Re: Christina Stacey - Followup question/detail for 75 Bay View Drive permit

Sincerely,
Chris Stacey
Zoning Specialist

MASTER SITE PLAN

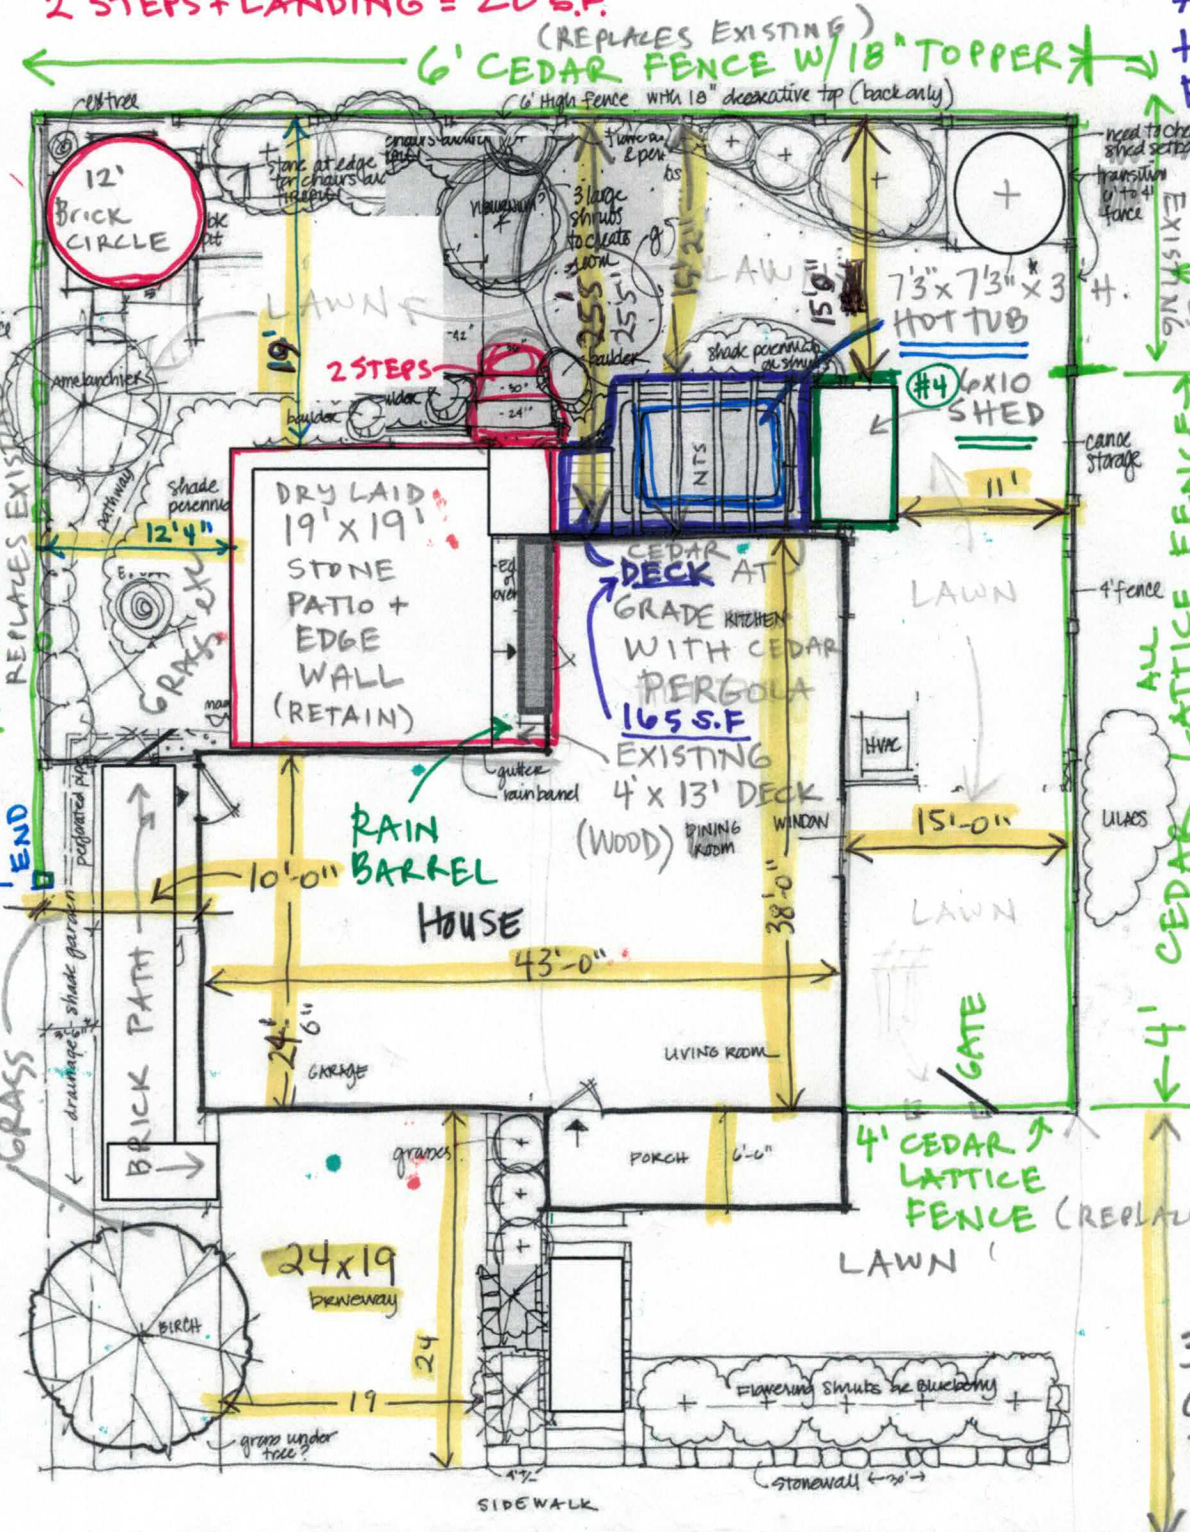
Thank you for being in touch. Yes, I started reviewing the permit and did have some questions about the setbacks. As you may have surmised, the normal rear setback in this zone is 25 feet. This may be reduced to 5' for detached accessory structures that are less than 144 square feet in size. Are the shed and hot tub deck/pergola going to be attached to or abutting each other in any way? If yes, the square footage of the total, combined structure would have to be less than 144 square feet in order to qualify for the lower rear setback. At 197 square feet total, the current configuration may be too large unless they are not touching. Also, will any of the shed or deck be attached to or abutting the principal house? If so, they would not be considered detached accessory structures and cannot qualify for the lower rear setback.

This department has always treated items like low decks and boardwalks as "structures" that must meet setbacks. The only exemption are features that are entirely at-grade, such as a patio, paved walkway, etc. Since the deck you describe will be constructed above the at-grade slab (even if only slightly), we would consider it a structure.

As far as square footage, we would normally be OK with not counting the square footage of the hot tub, since a hot tub alone is not considered a "structure" and it will simply be sitting on an at-grade slab and not on decking. However, the construction of the pergola over the hot tub and deck complicates things, as we would consider the pergola to be a structure with a square footage of its own, regardless of what is underneath it. Since the pergola will also be attached to the shed, we would look at this as one combined structure (shed/pergola, with the hot tub deck surround underneath) with a square footage of approximately 246 square feet (this is the best I could scale off the plan: 60 sq ft shed, ~165 sf pergola, and ~21 sf deck ell?).

- 1) Remove the pergola from the plan, and just have the hot tub with deck surround (79 sf) and a non-touching shed (60 sf) which would create two separate structures small enough to qualify for the reduced rear setback
- 2) Construct the pergola and deck surround without any attachment to the shed, and reduce the pergola to be 144 square feet or less (with the tub and deck surround entirely underneath, thereby qualifying for the reduced rear setback).

We have a 13'x10.5' concrete slab-on-grade (4") which is next to the house, on which the hot tub (65 sf) will sit. The "deck" is built on the slab ("floating" in the term our contractor uses) to surround the tub and conceal the slab and sits at ground level with no entries to/from house, etc. It is not clear whether this is technically a "deck" vs. some sort of hardscape feature or boardwalk, likely leading to much of the confusion on our part. The actual square footage of the wood decking/boardwalk around the tub is about 79'.

Meanwhile, we have the 60 sf shed which sits on piers next to the slab (unattached to slab or deck, but abutting), to which one end of the pergola structure is attached. The pergola then extends over the slab to posts on separate piers. Neither the shed nor the pergola are attached to the house.

Thank you Chris. We are revising the design to meet the requirements of the shed and pergola being detached. I will send the plan shortly. Do we assume that others in our zone whose accessory structures are not meeting setback requirements (either close to rear property line or over the 144 SF) got variances? Or perhaps requirements have been revised since theirs were built? That is why I asked if we could meet to discuss, to see if we could get one.

DWG. (3) 12'-6" x 7'-6" PERGOLA  
 ELEVATION N  
 15 DEG VIEW  
 DRG  
 DECK/HOT TUB/  
 PERGOLA/  
 SHED

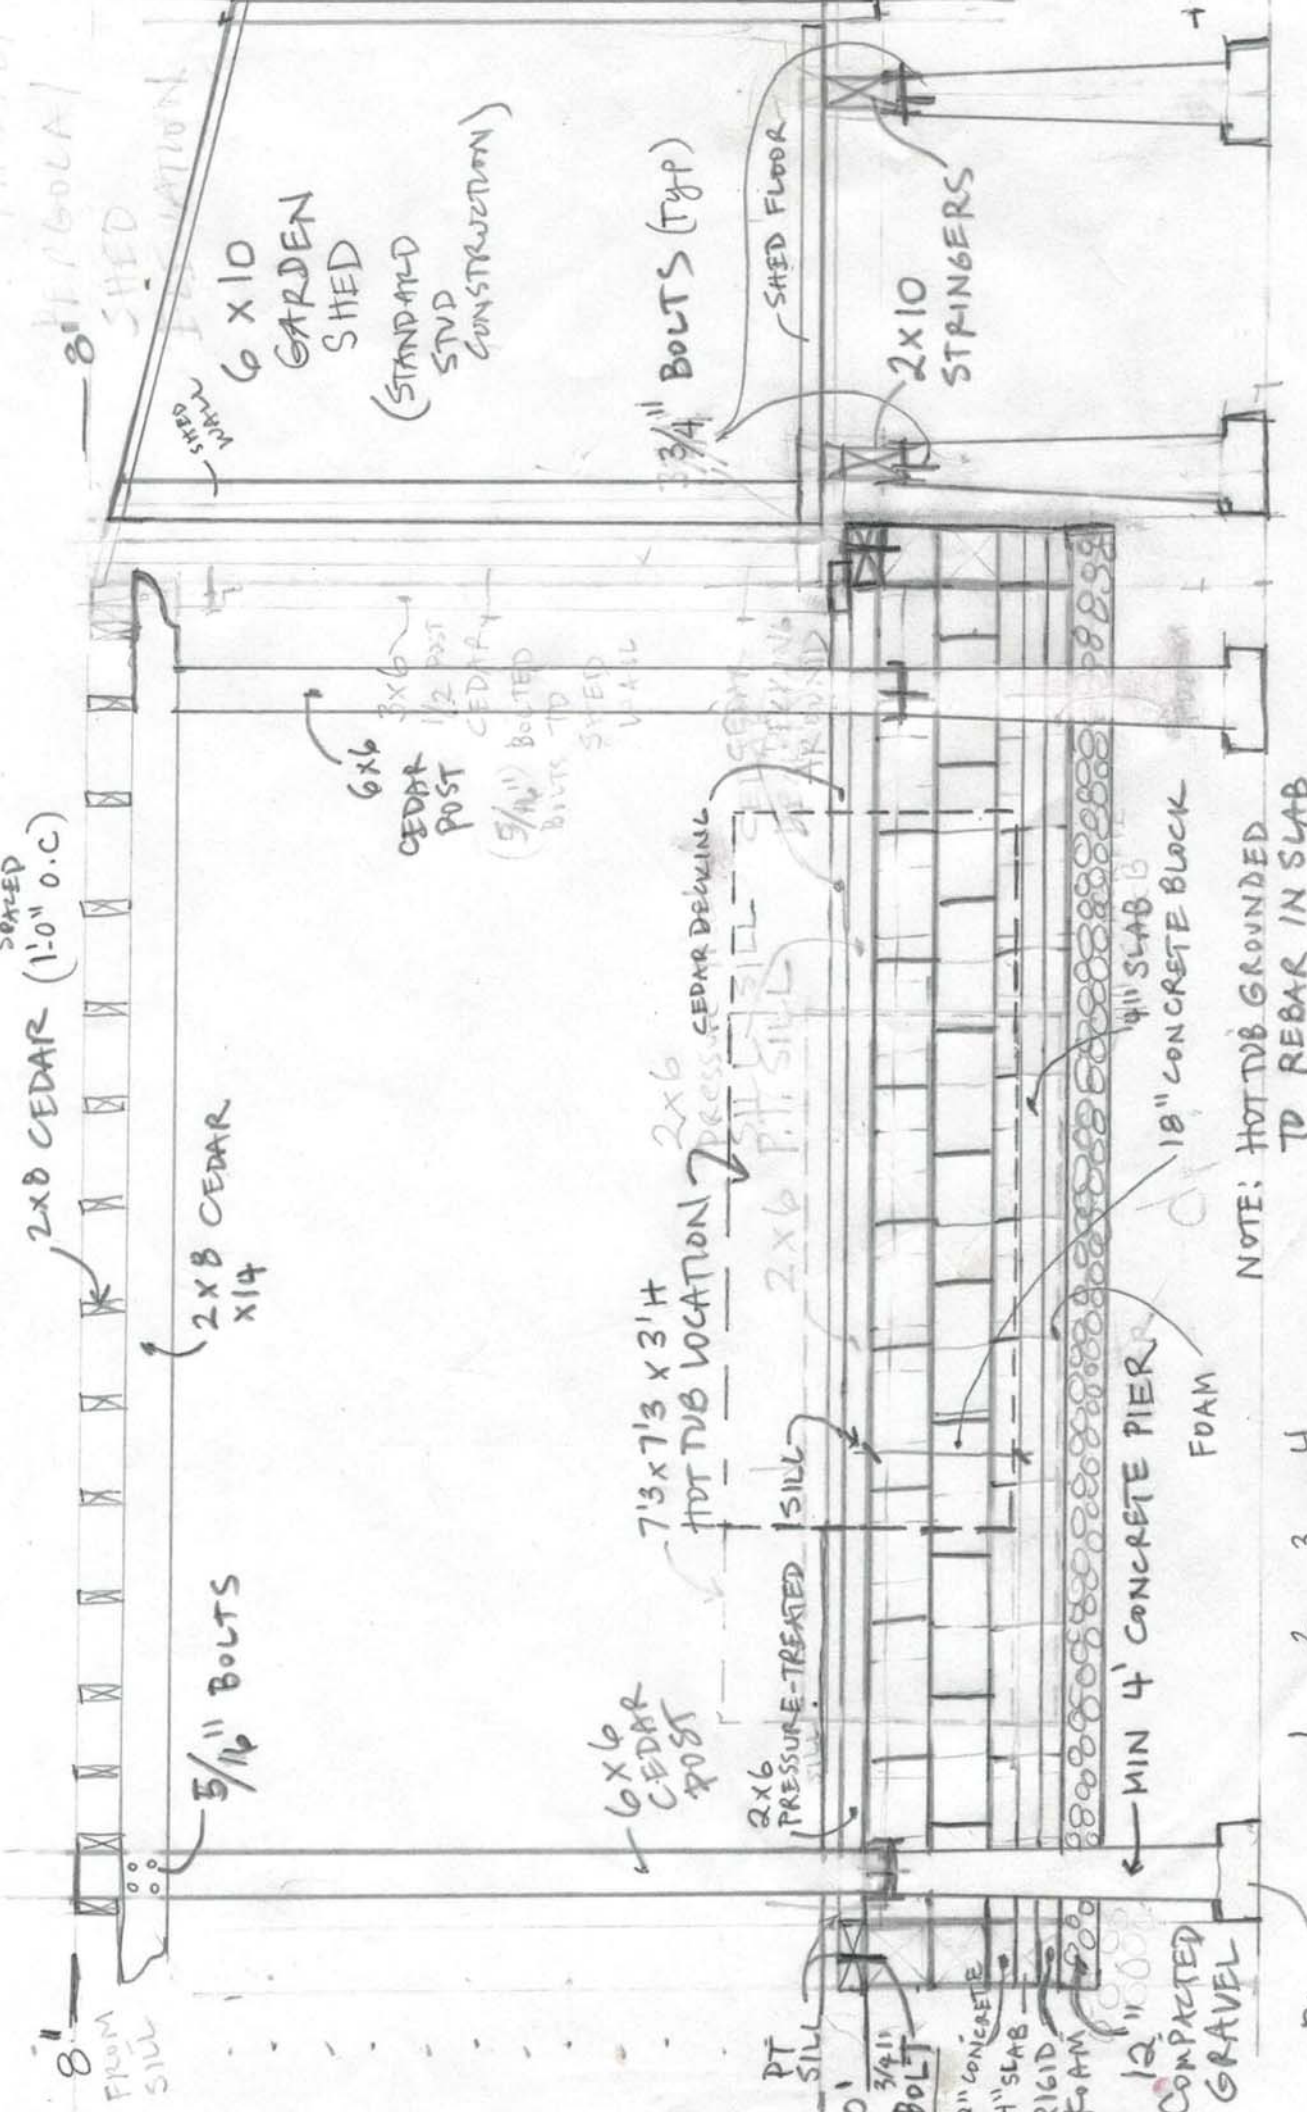
What are the final dimensions of the pergola? I'm scaling it at about 10' by 13' (excluding the wall surround), which is 130 sq ft, but then there's a little "ell" or step(?) off to the left that shows another 30 sf, which would put you over the 144 sf. Any clarification would be helpful.

Hi Chris - The pergola dimensions are 7'-6" x 12'-6". The pergola does not extend to the "ell". The concrete wall is below grade.

The "ell" is an at-grade extension of the patio - at the exact same level, which is the original ground level around the edge of the house. We are excavating to put in support to maintain that ground-level continuity.

OK, we have discussed the project and decided not to do the pergola. Do I need to resubmit anything?
